**19955 Wigwam Road, PPR-24-7**

Please accept the following comments from El Paso County Public Health (EPCPH) regarding the project referenced above:

Mike McCarthy  
El Paso County Public Health  
719-332-5771  
[mikemccarthy@elpasoco.com](mailto:mikemccarthy@elpasoco.com)  
10May2024

GRADING & EROSION CONTROL PLAN

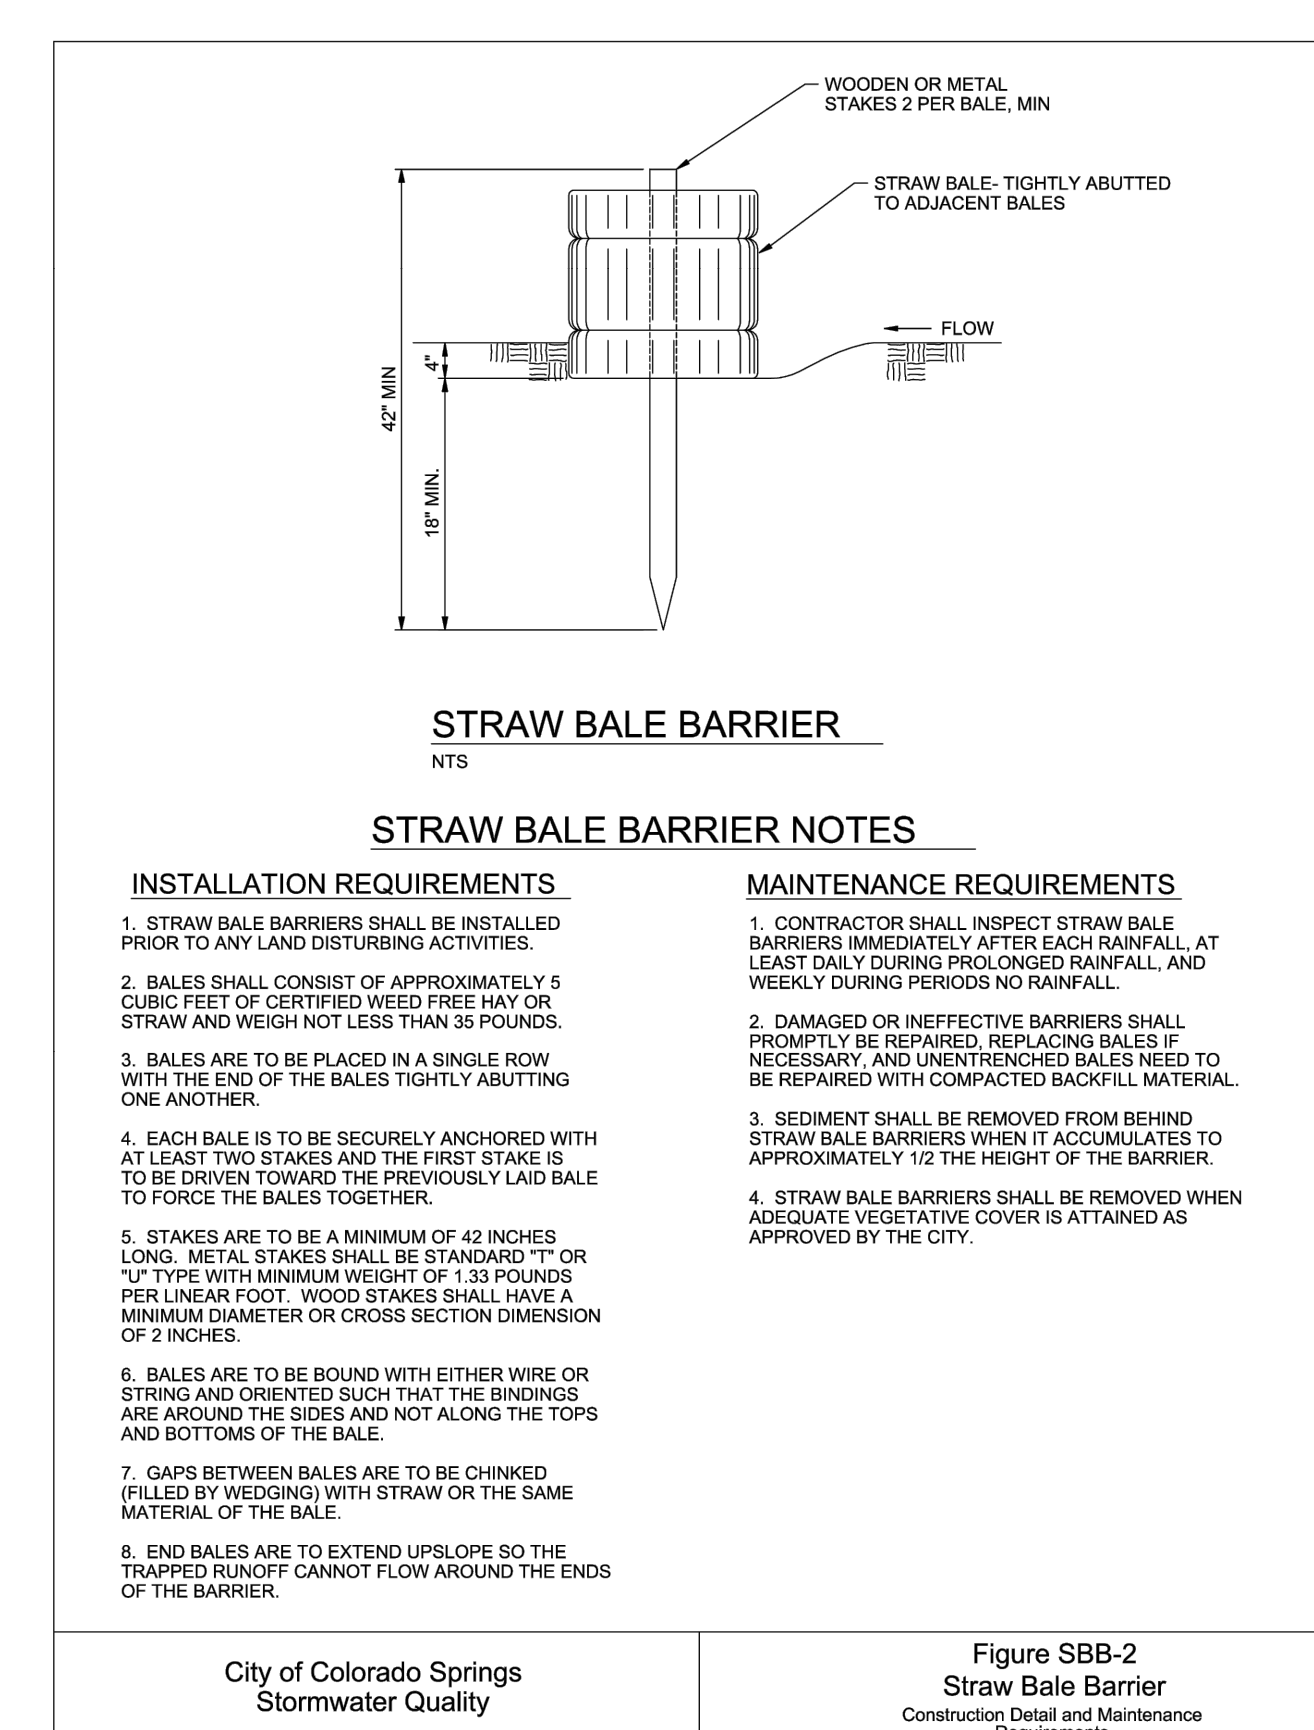
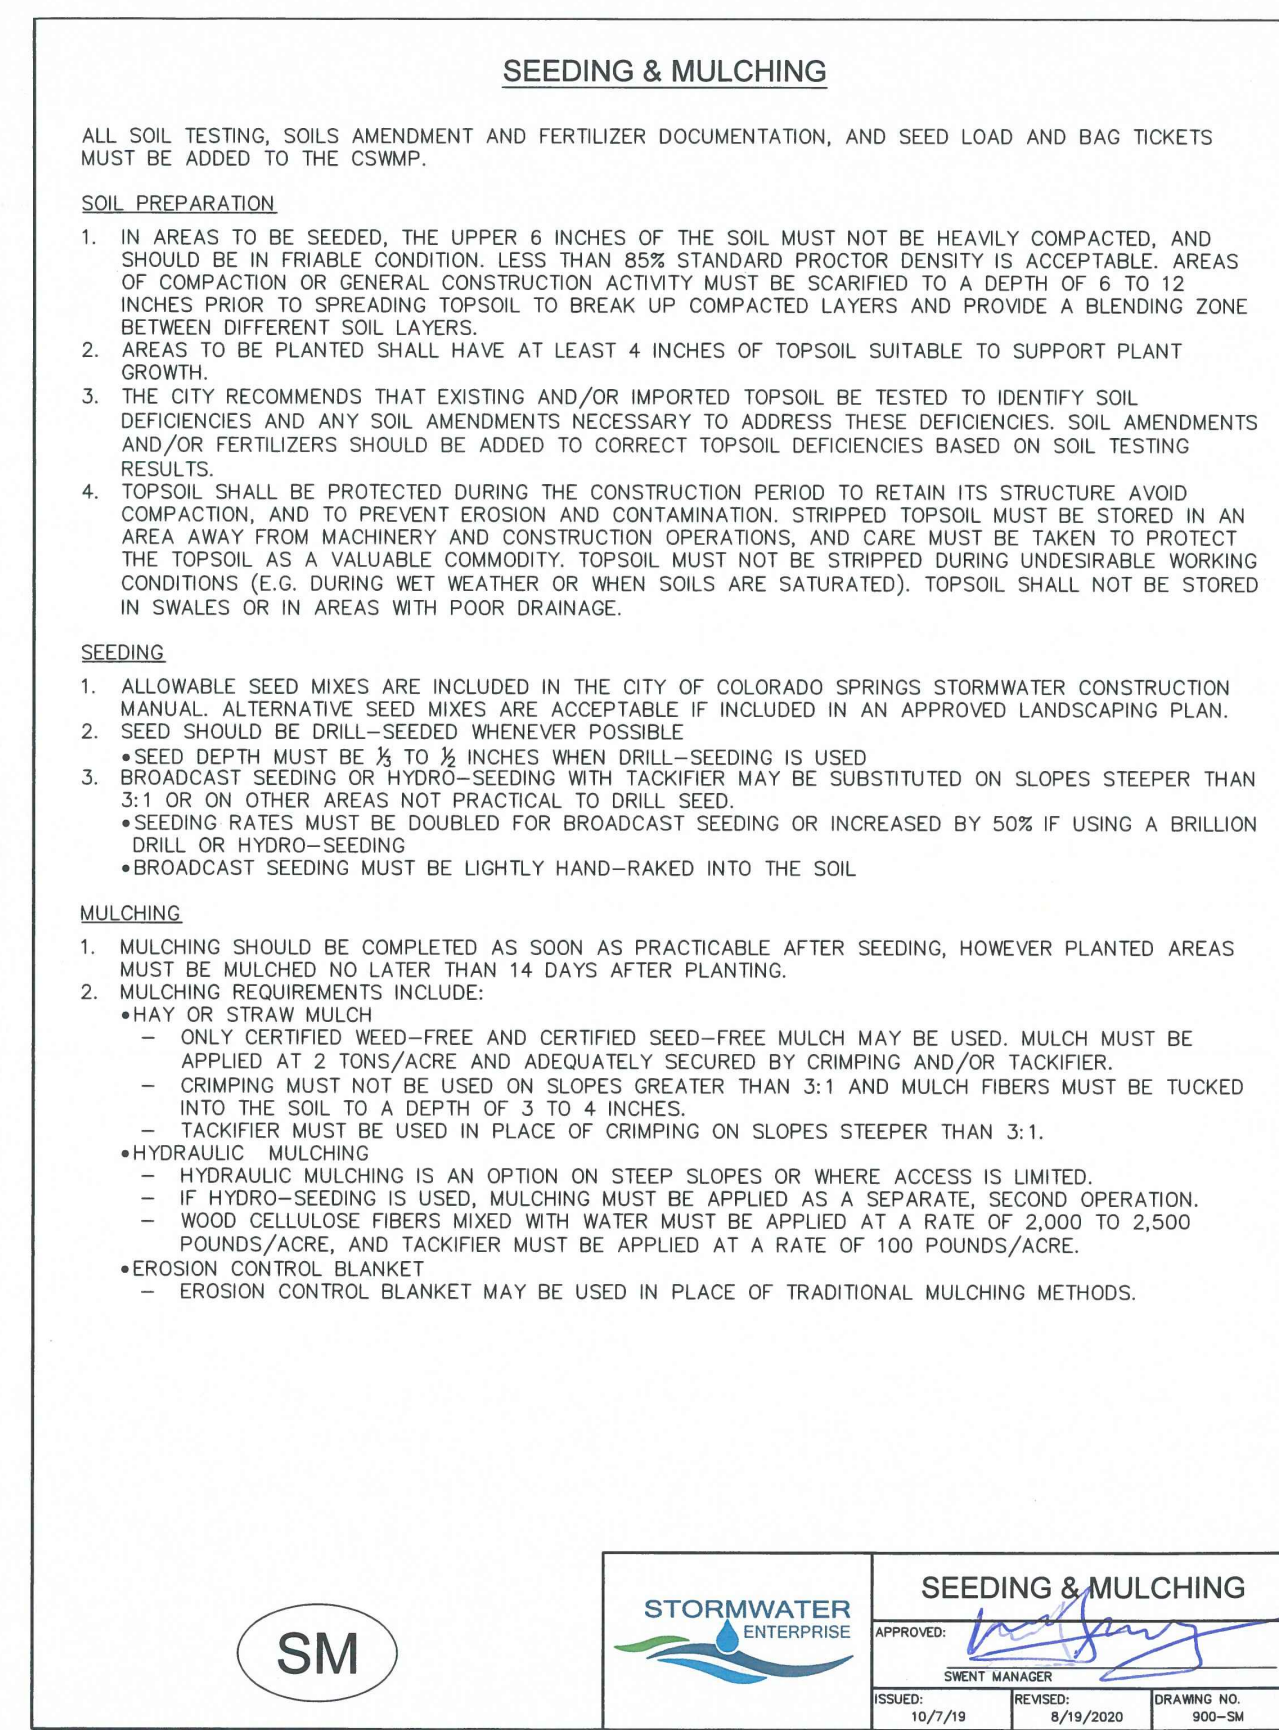
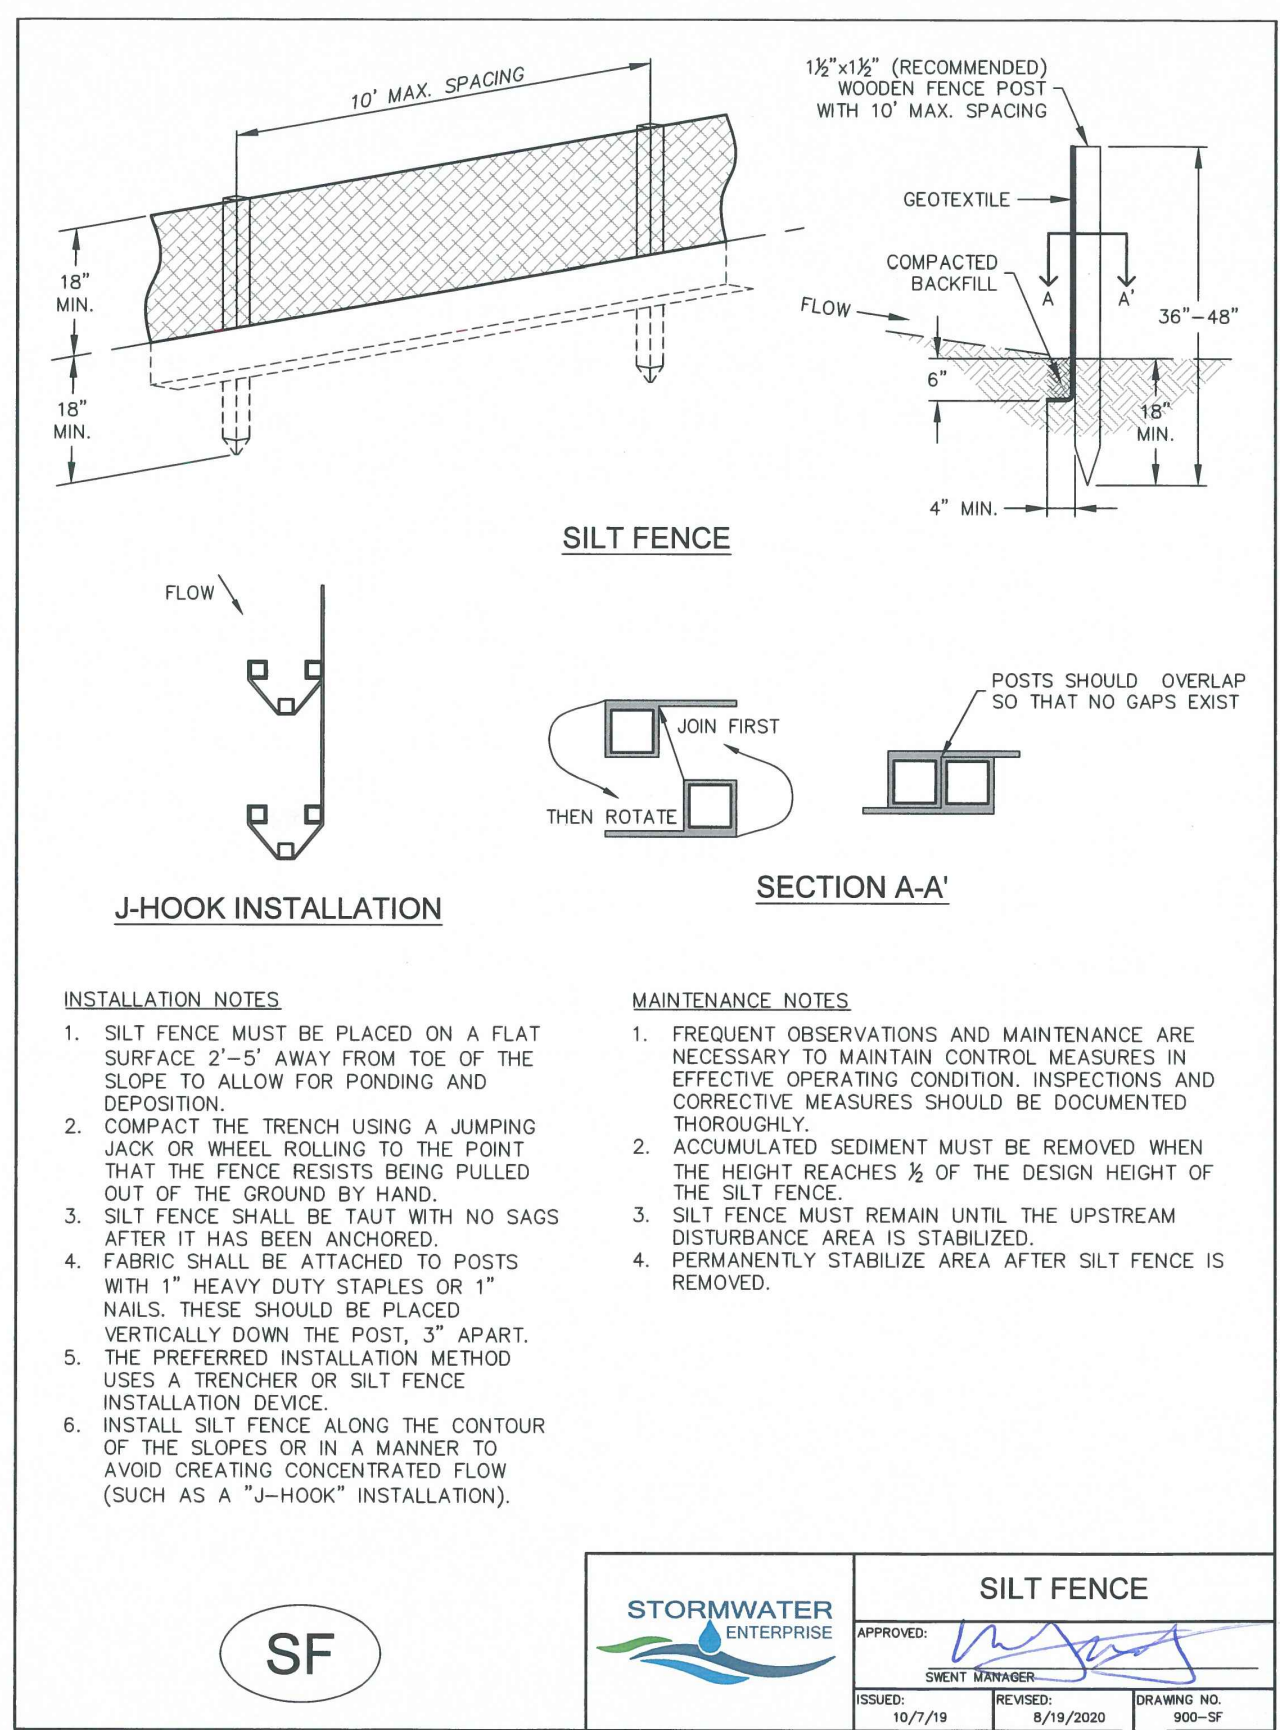
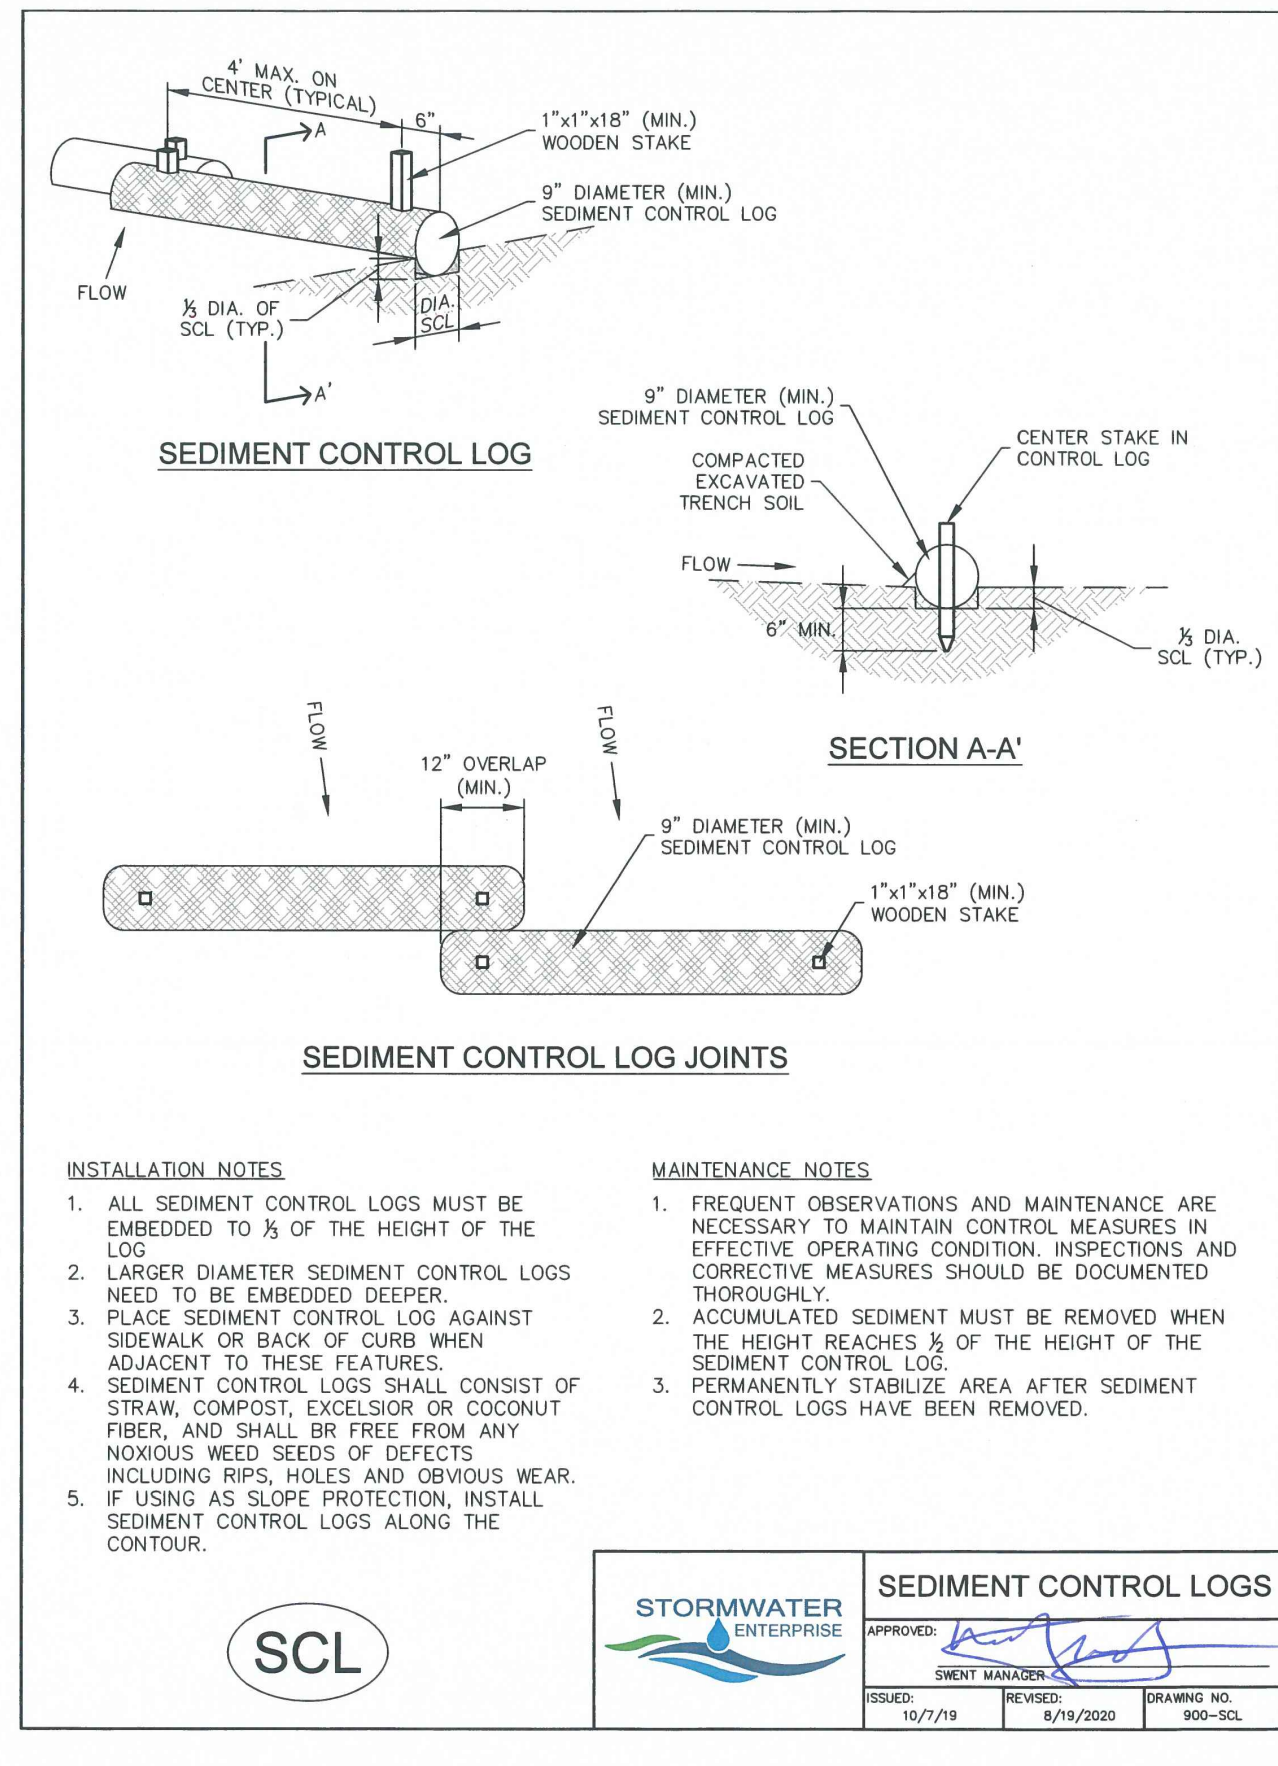
- Earthmoving activity in excess of one acre, but less than twenty-five acres, requires a local Construction Activity Permit from El Paso County Public Health. Go to <https://www.elpasocountyhealth.org/service/air-quality/construction-activity-application> for more information.
